7 April 2016

Response to Submissions – ATP Development

JBS&G Australia Pty Ltd (JBS&G) have been engaged by Mirvac Projects Pty Ltd (Mircvac) for the provision of environmental consultancy services associated with the remediation and redevelopment of a portion of the Australian Technology Park (ATP), herein referred to as the site. As part of this engagement, Mirvac have requested JBS&G to provide supporting evidence to close out the following enquires/comments:

proposed building envelope diagram

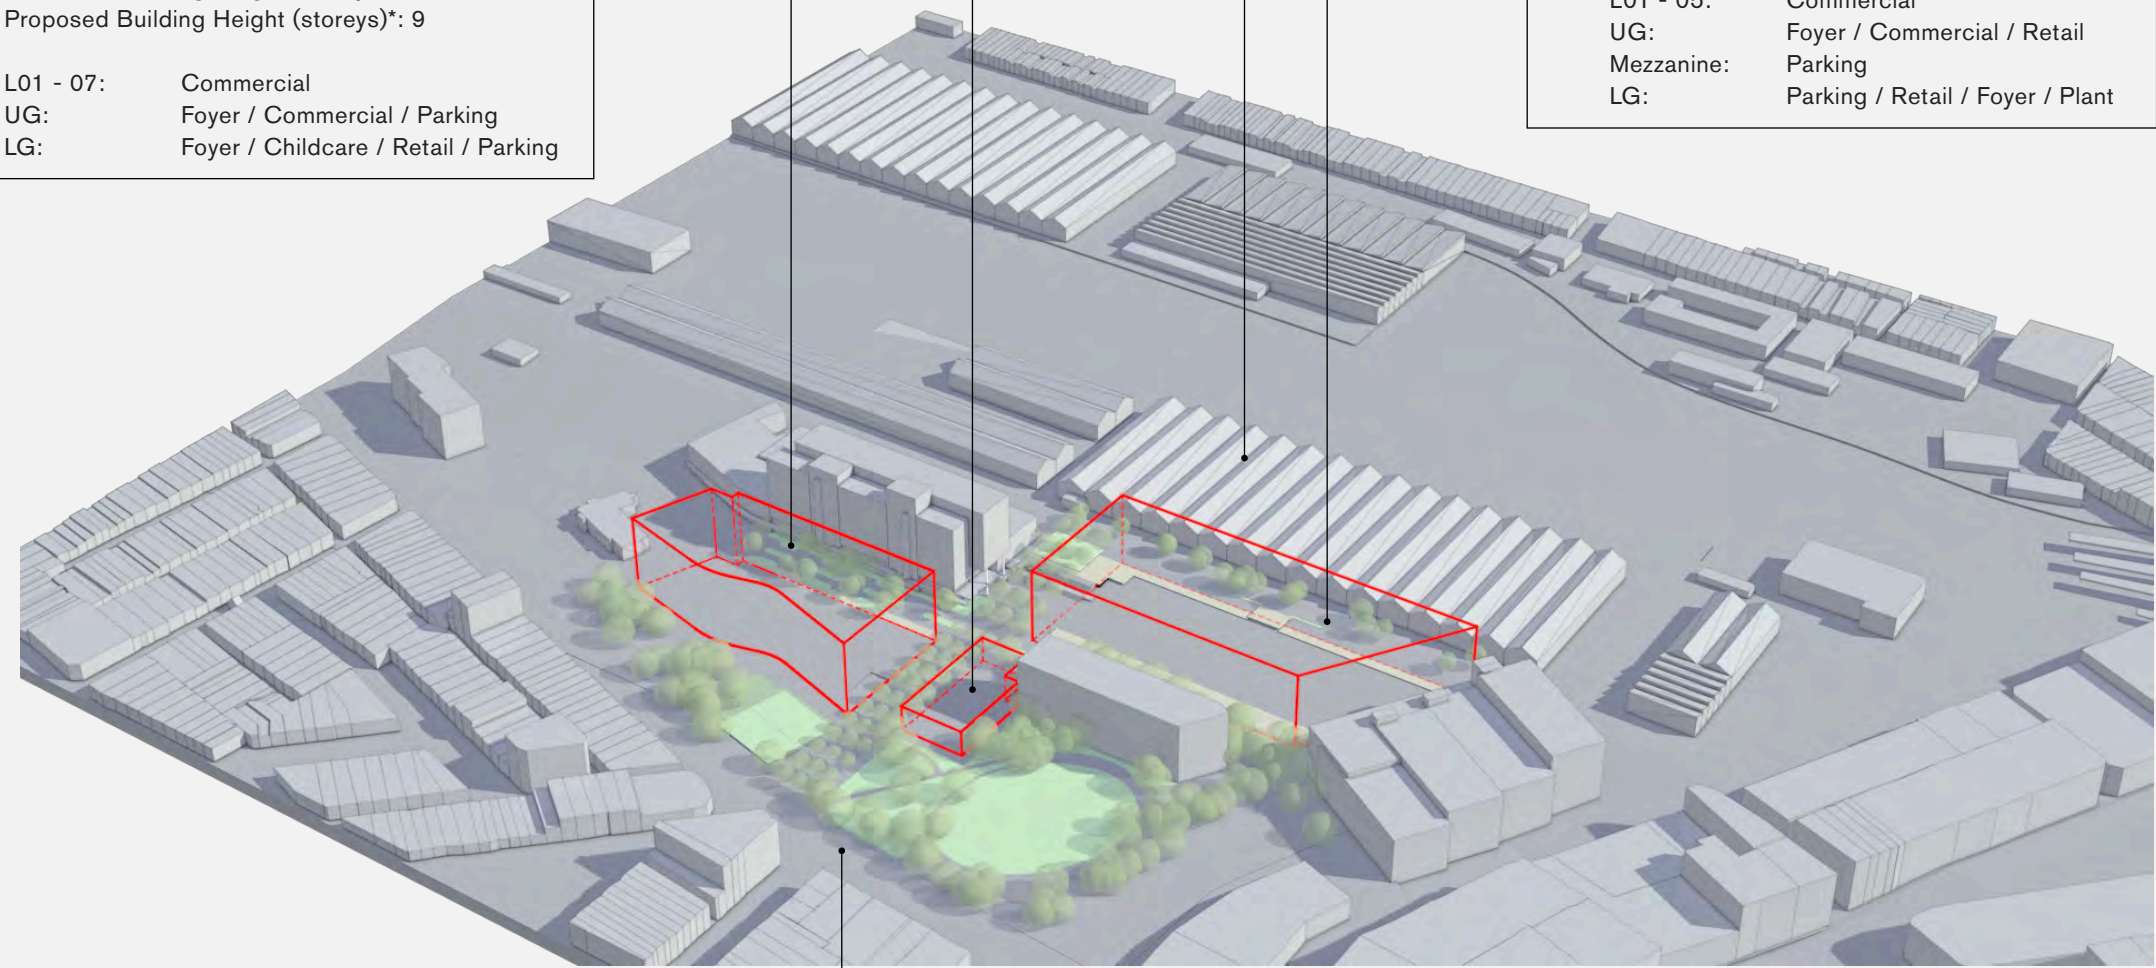
Comments from the Department and Council – Consideration to be given to the form and mass of Building 1 including relocation of parking to basements.

Should the proposed parking arrangements be modified to accommodate basement parking rather than at grade, fill materials would require off-site disposal to a landfill lawfully able to accept them. In doing so, consideration should be given to the following:

- Disposal of fill materials to landfill may have significant implication to the Green Star and Ecologically Sustainable Development objectives, and will not meet waste minimisation objectives of the *Waste/Avoidance and Resource Recovery Act 2001*;

- The NSW waste hierarchy prefers on-site retention of fill by means of cap / cover as opposed to off-site disposal to landfill. As such, excavation of fill materials and disposal to landfill is not acquiescent with current EPA guidance;

- Changes to the design would need to consider the increase in truck movements. Based on review of the current design plans, all fill materials are proposed to be retained on site, thus reducing truck movements and disruption to ATP tenants and the surrounding community;

- Consideration needs to be given ATP neighbours including the childcare centre. The additional bulk excavation activities to facilitate basement parking has the potential to result in increased dust emissions,

- Shallow groundwater conditions are present within this portion of the ATP site. As such, consideration needs to be given to the design of the basement and the potential for long term ongoing groundwater management (i.e. treatment of any basement groundwater ingress before being discharged to sewer under a trade waste agreement with Sydney Water or similar); and
- To facilitate bulk excavation activities, a dewatering license may be required to be obtained from the NSW Department of Primary Industry (previously the NSW Office of Water).

**HISTORIC EXCEEDANCES  
IN GROUNDWATER**

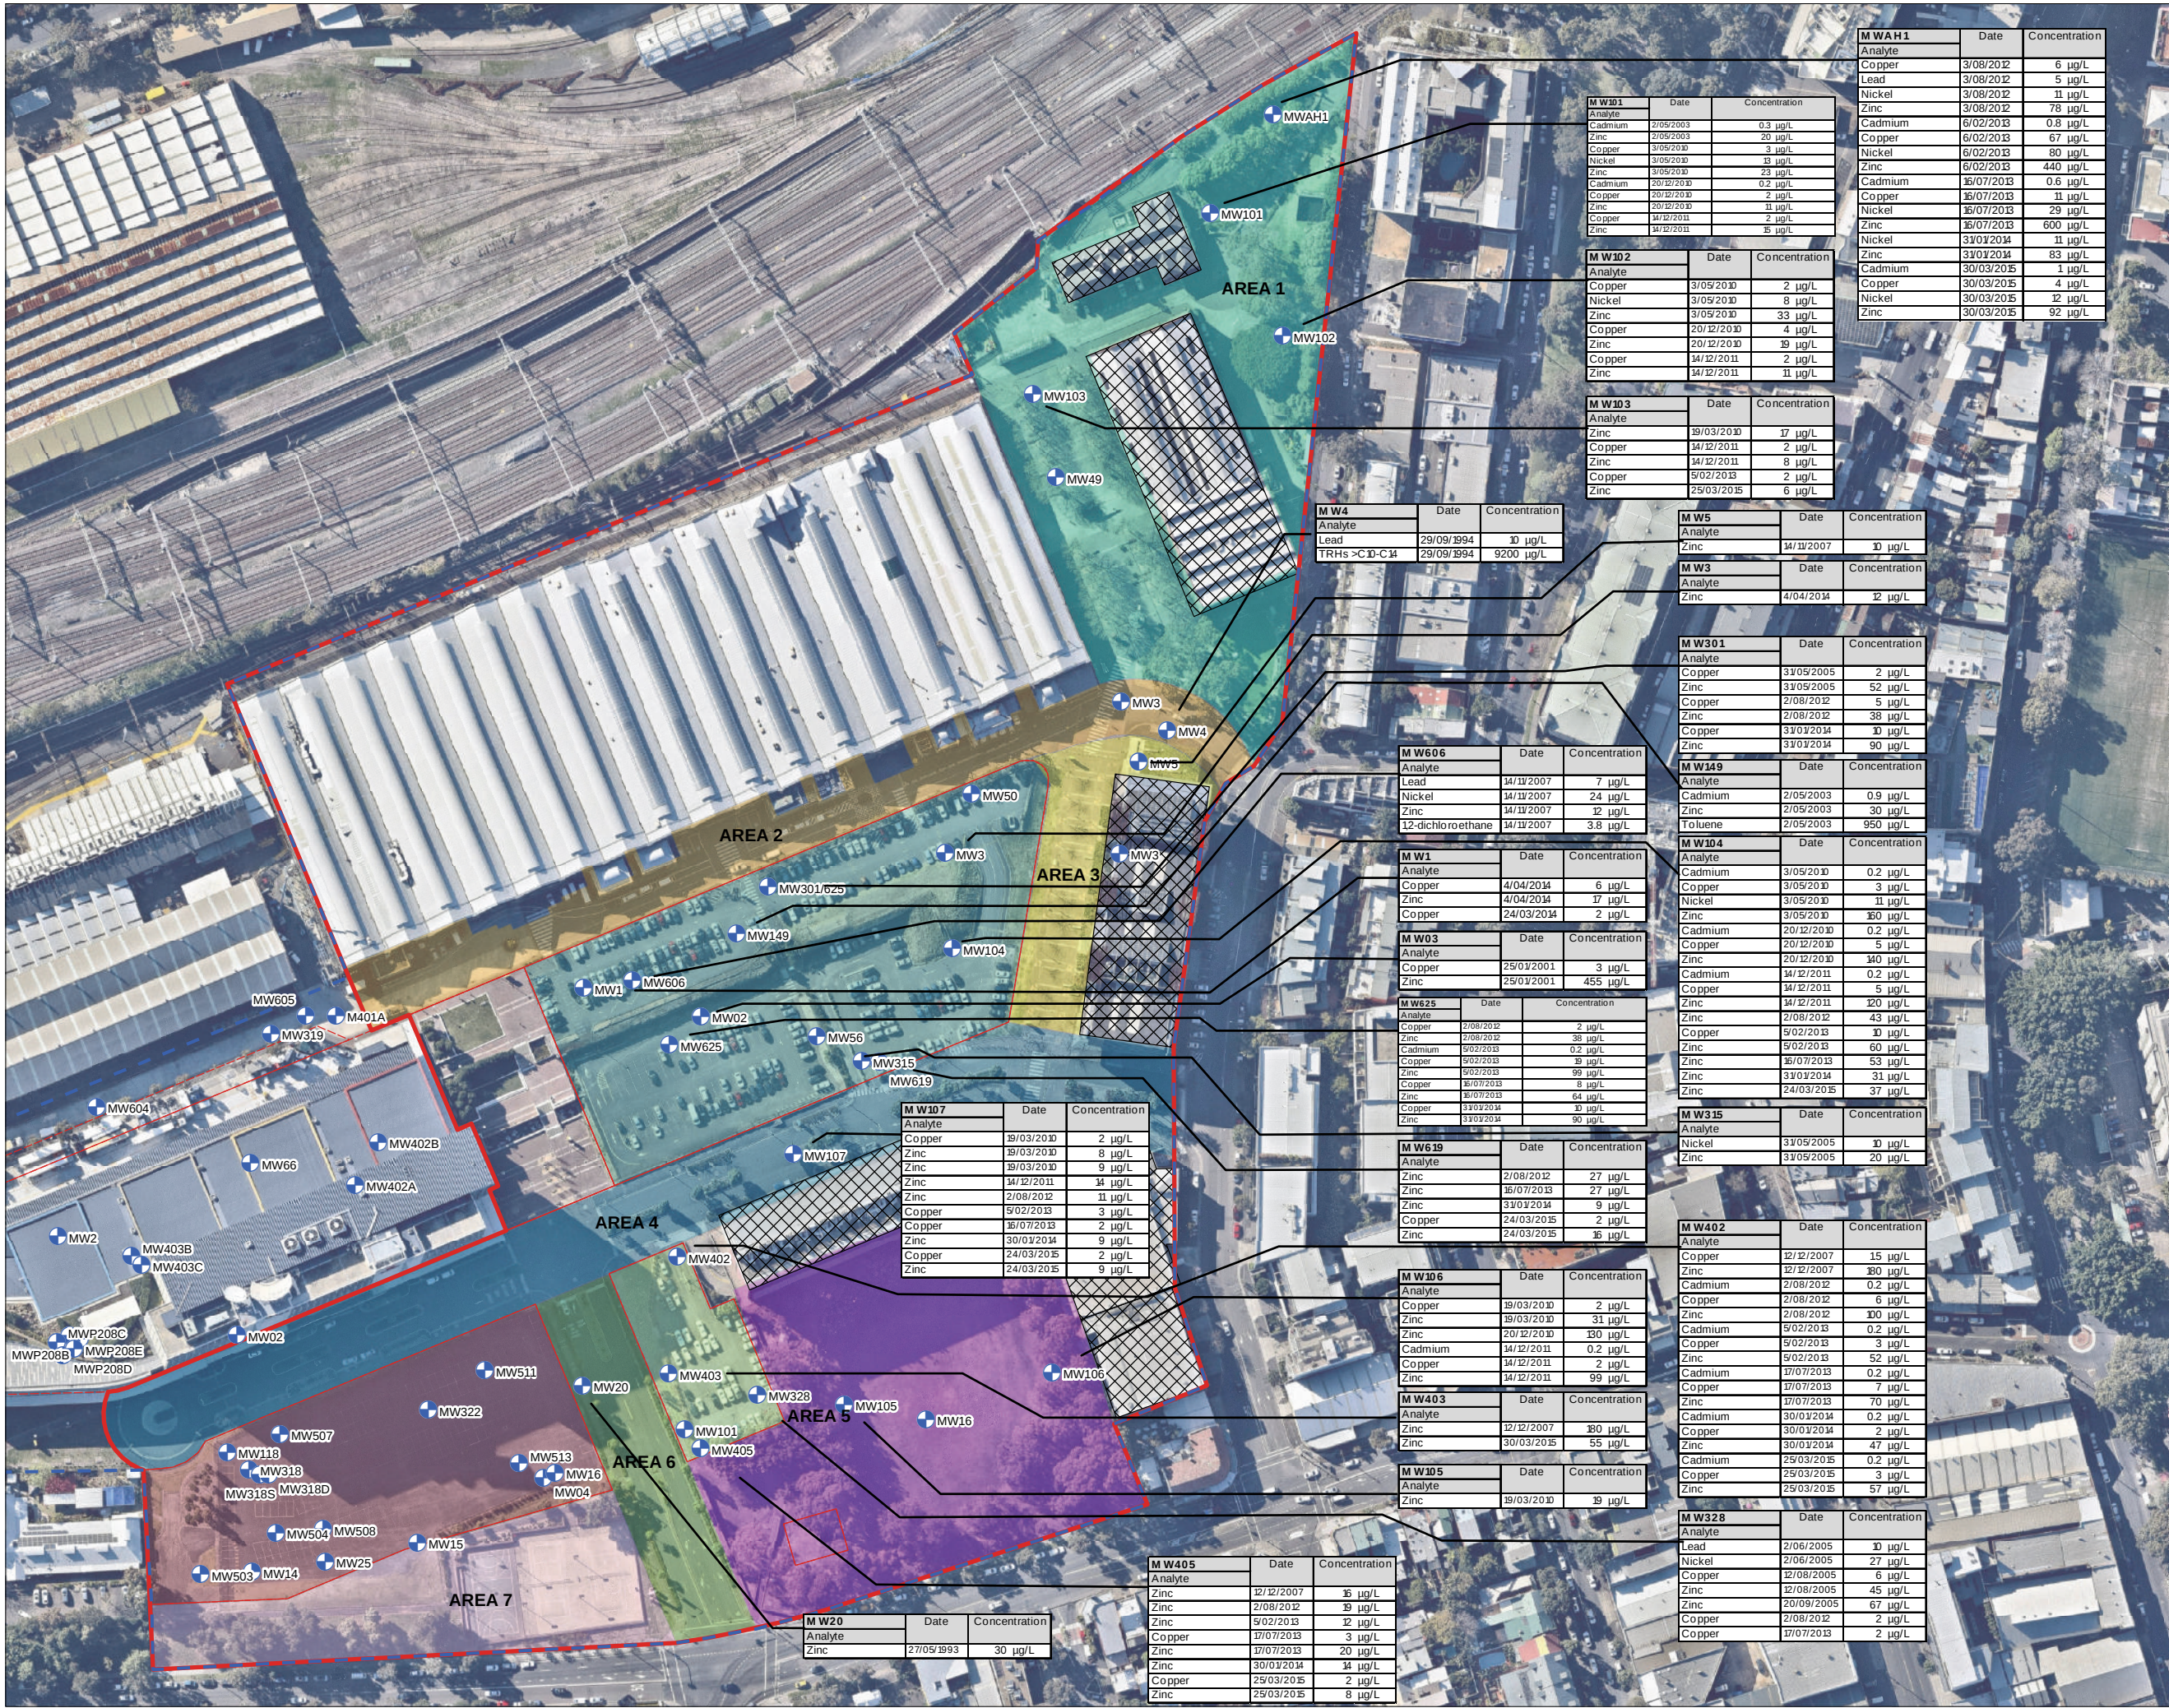
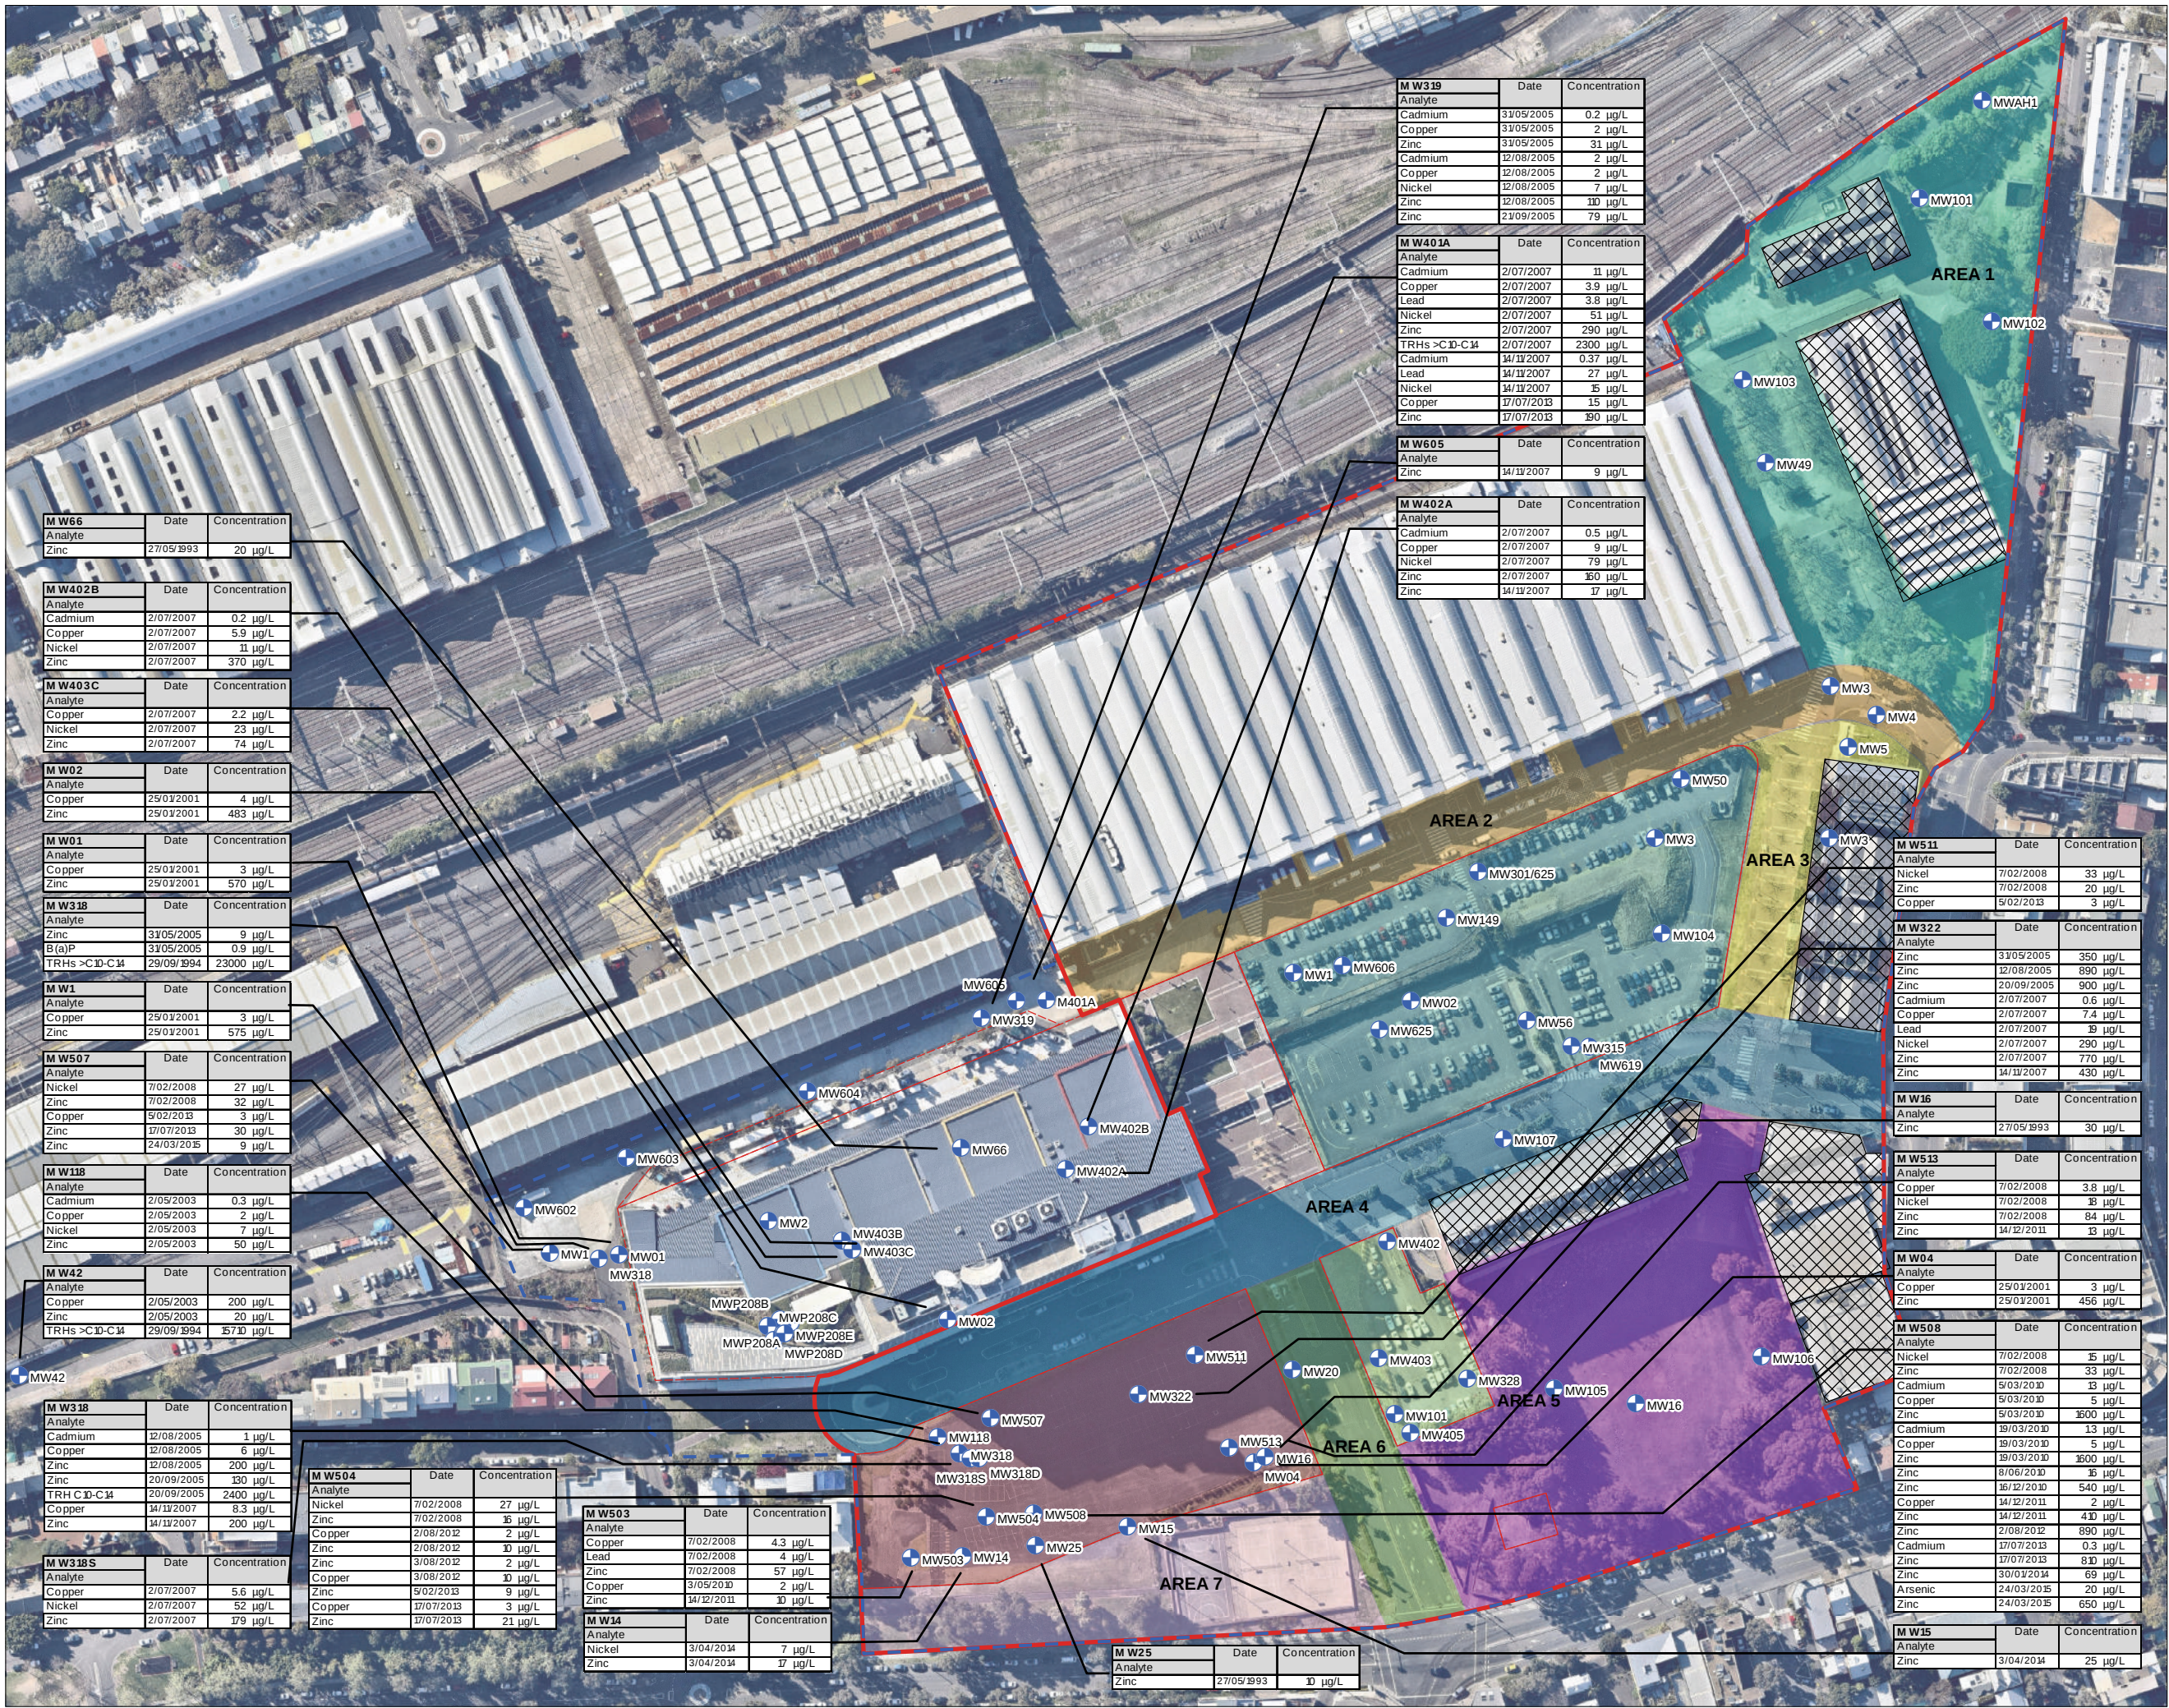
Contamination and Remediation – Clarify groundwater contamination and remediation method. Mirvac to engage with JBS&G plus the auditor to ensure the release of the Site Auditor Statement.

Previous interim Site Audit Reports noted that groundwater has been assessed as part of the greater ATP site and that no groundwater remediation is considered to be required. Reference should be made to Site Auditor advice Ramboll (2015¹).

As discussed in the RAP prepared for the site, groundwater conditions are considered typical of inner Sydney urban environments with slightly elevated heavy's metals, and to a lesser extent PAHs, and do not require specific remediation with respect to protection of the environment. In addition, site fill materials have been reported as having non to low leachable properties and do not represent an unacceptable migration risk to groundwater. As such, groundwater remediation is not considered warranted.

JBS&G consider that groundwater has been adequately assessed and will be managed via the Site Audit process.
